Subject: AW/128/12 - 2 no. windows on existing extension at 12 Chawkmare Coppice, Aldwick.

Subject: Our Ref: 4682 re: New Windows to West Elevation - 12 Chawkmare Coppice, Aldwick.

PLANS & ELEVATION. [AS REDLINED.]			
Scale	AS NOTED. @ A3	Drawn By	
Date	MAY. 12.	Checked	
Drawing Number	4682/1 x B.

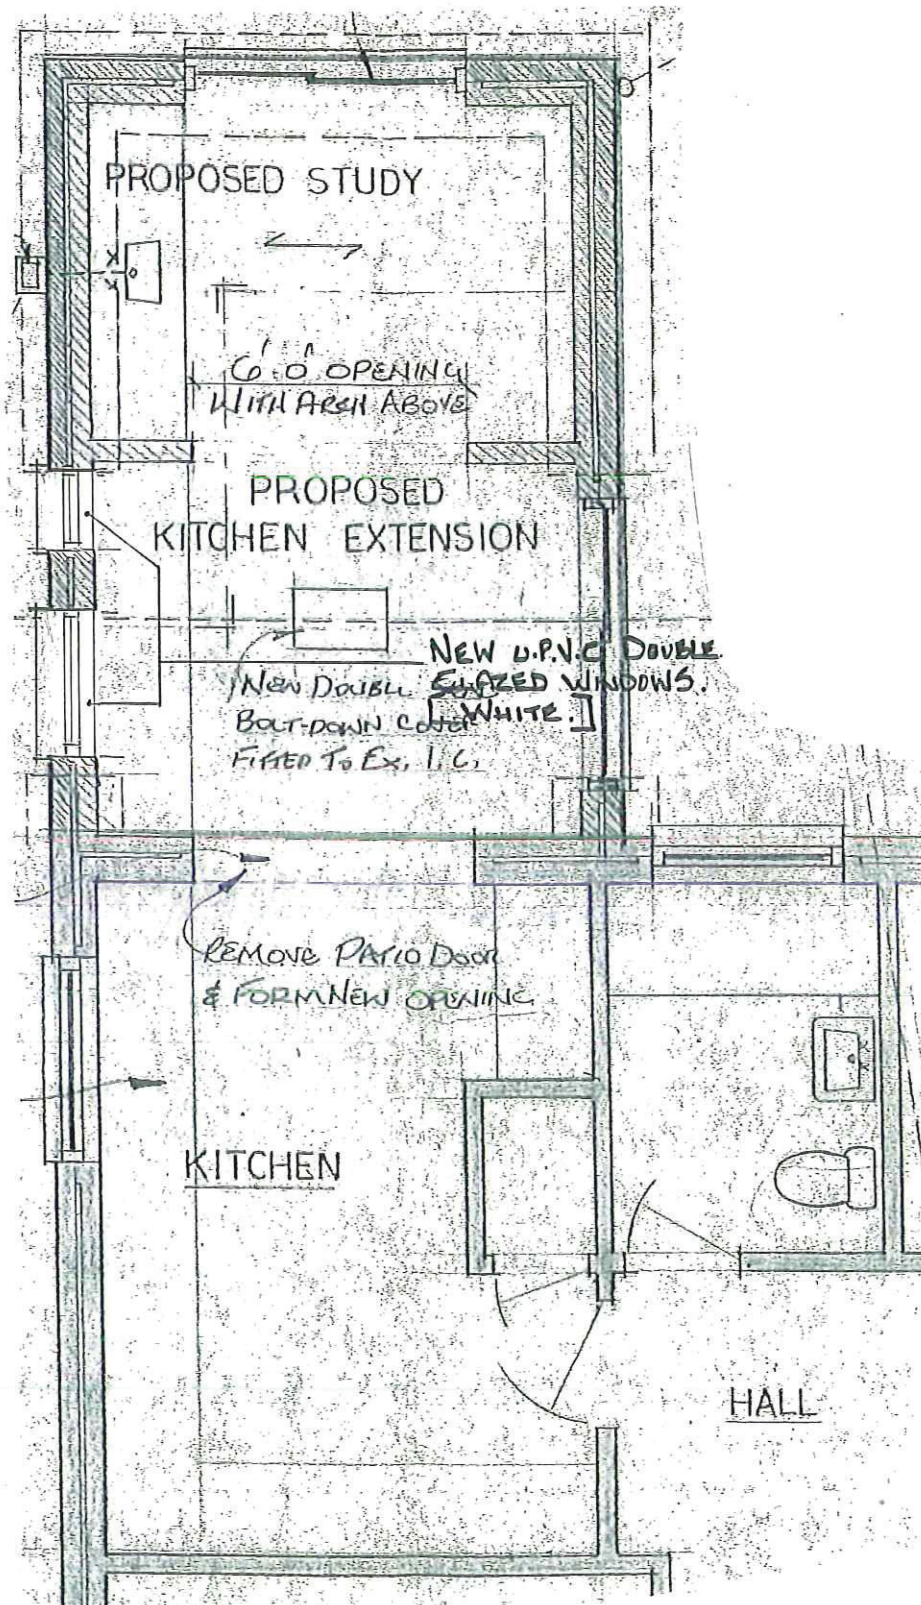
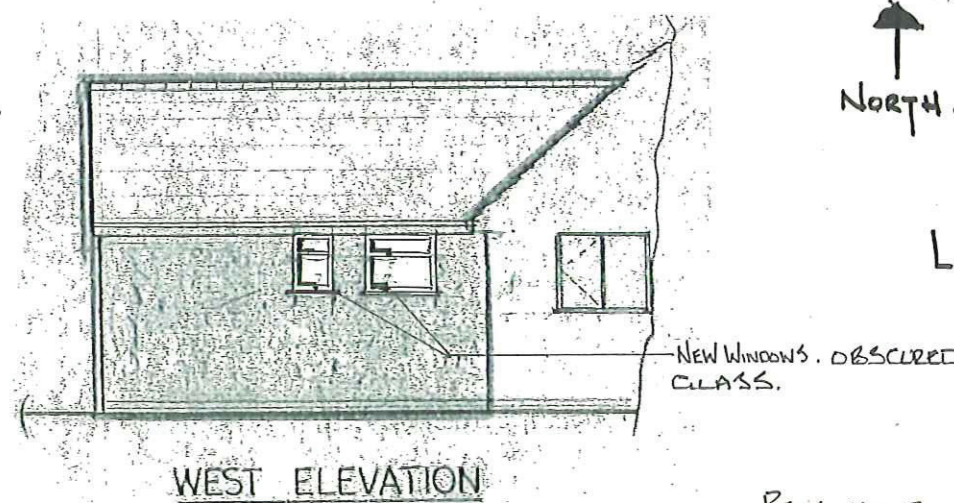
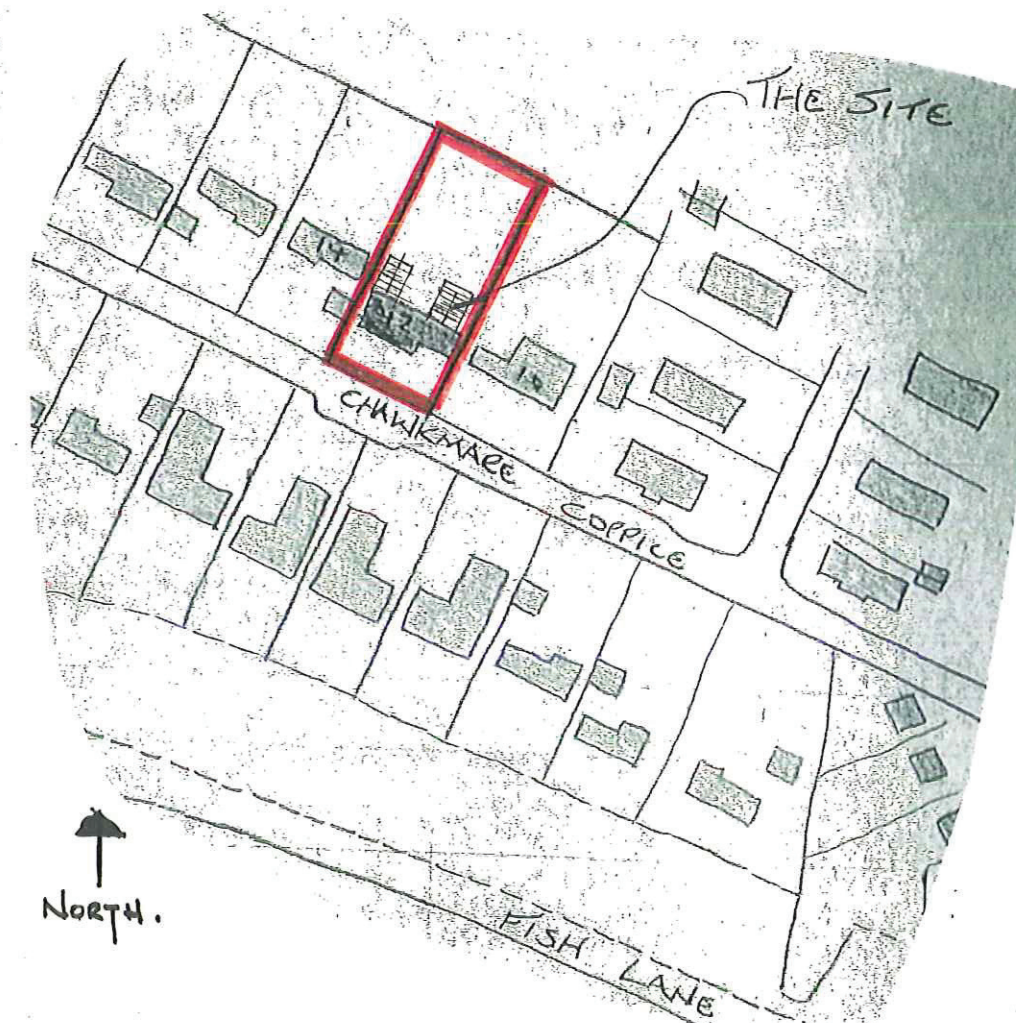
Can you confirm that the windows installed in the rear extension have been manufactured with obscure glazing and not just a transparent film has been applied. I am afraid that this will have to go to the next Committee on the 22nd August as there has been a Parish Council Objection.

Please can you also re-send the existing floor plan and elevation. Both the existing and proposed plans need to show a scale (usually 1:100 or 1:50). We are unable to accept imperial measurement, so the reference to inches on both plans will need to be removed.

Please can you re-send the 2nd part showing a north point in relation to the location plan and site plan and either add the red edging (as this has been missed off the plan provided) or confirm in writing that I can mark the red edge on the plan.

Further to your email dated 20th June 2012 I attach herewith amended drawing Nos 4682/1xb & 2xa giving details of amended scales and addition of North arrows to site and block plan.

As of your first comment I give you permission to mark the red edging on the plan.

Firstly, the north direction is indicated in the title block. We have, however, added the extensions onto the location plan.
